Kate MacDonald - RE: SSD 12_5582 - Establishment of First Use and Fit-Out of Levels 1 to 28 of Commercial Building C4, Barangaroo South

SSD 12_5582 – Establishment of First Use and Fit-Out of Levels 1 to 28 of Commercial Building C4, Barangaroo South

Figure 6 Key Walking Routes from the C4 Building

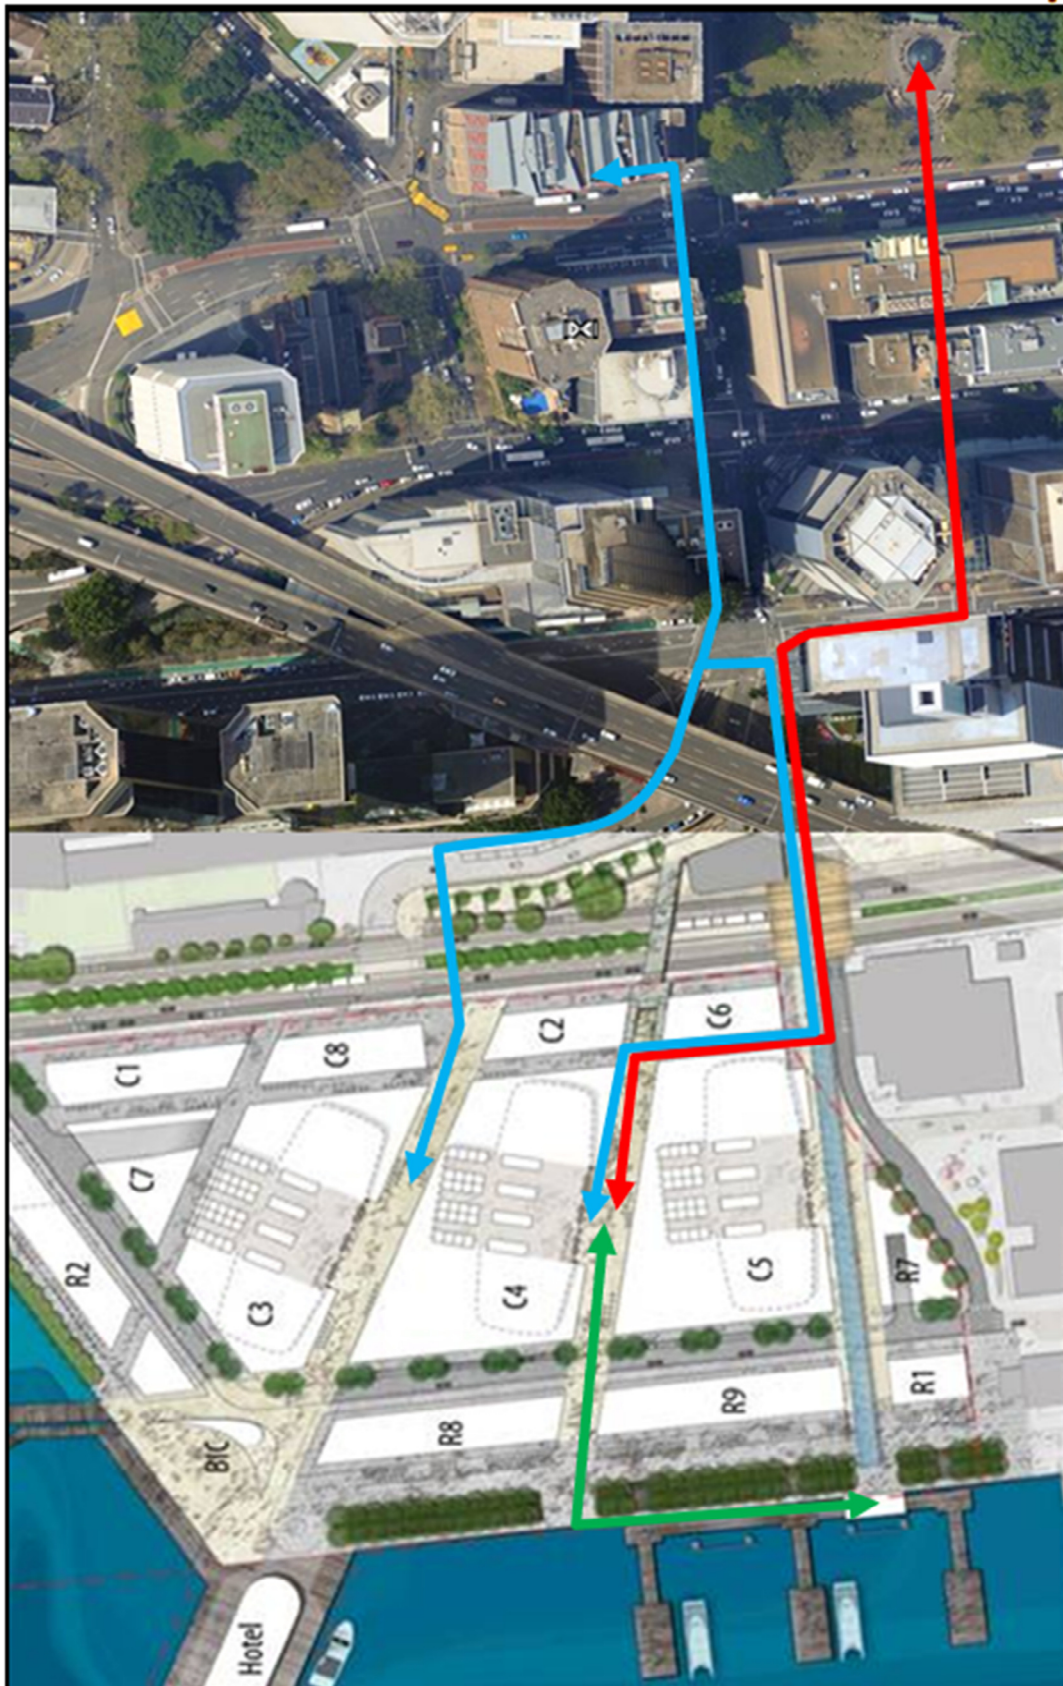
1. Section 2.2 Cycling Access – The NSW Government is currently considering strategic cycling networks in the *Sydney City Centre Access Strategy*. Potential differences between the City of Sydney *Cycle Strategy and Action Plan 207-2017* and the *Sydney City Centre Access Strategy* should be checked when it is released to verify assumptions made in this application and any amendments that may be necessary.

Figure 8 Sydney Light Rail Preferred Route

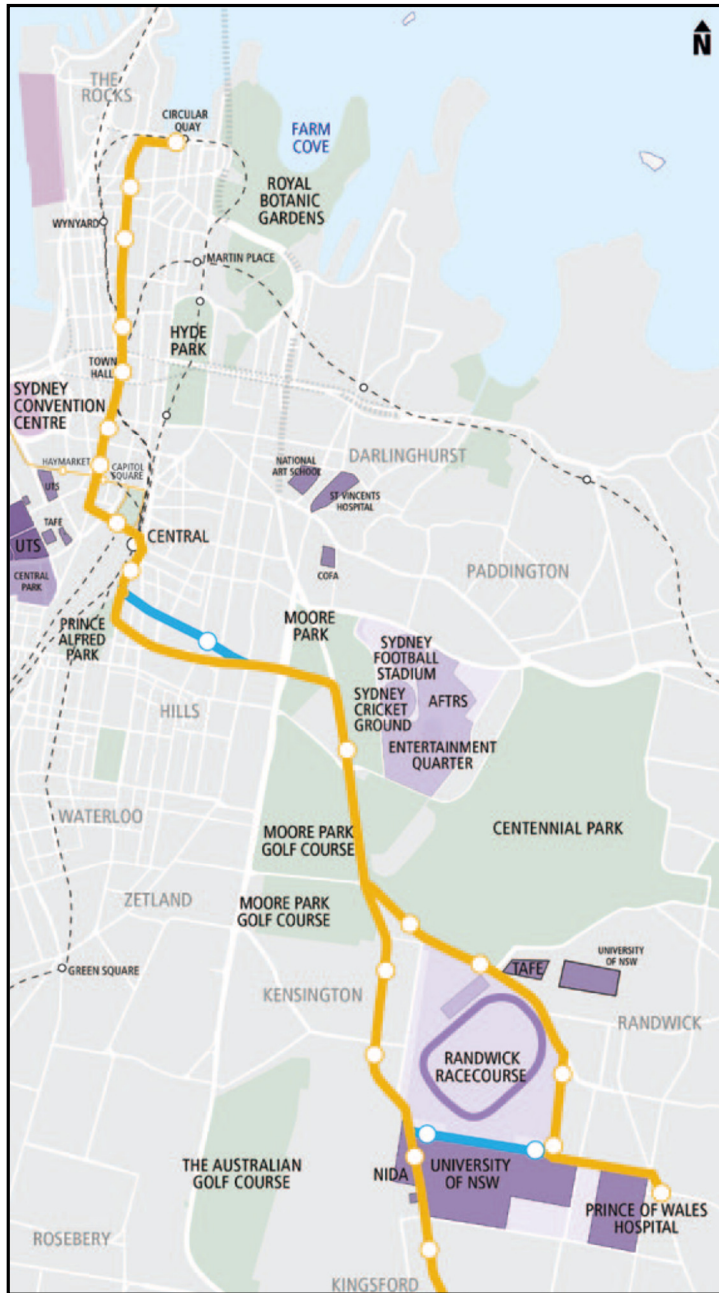
2. Section 2.3.1 Sydney Light Rail – This section of the report is out of date by approximately one year as it is referencing 2012-13 budgets and consultants being appointed for a Strategic Light Rail Plan that was completed in late 2012. There is no recognition of *Sydney's Light Rail Future* or the announcement of the *CBD and South East Light Rail* project both made on 13 December 2012.
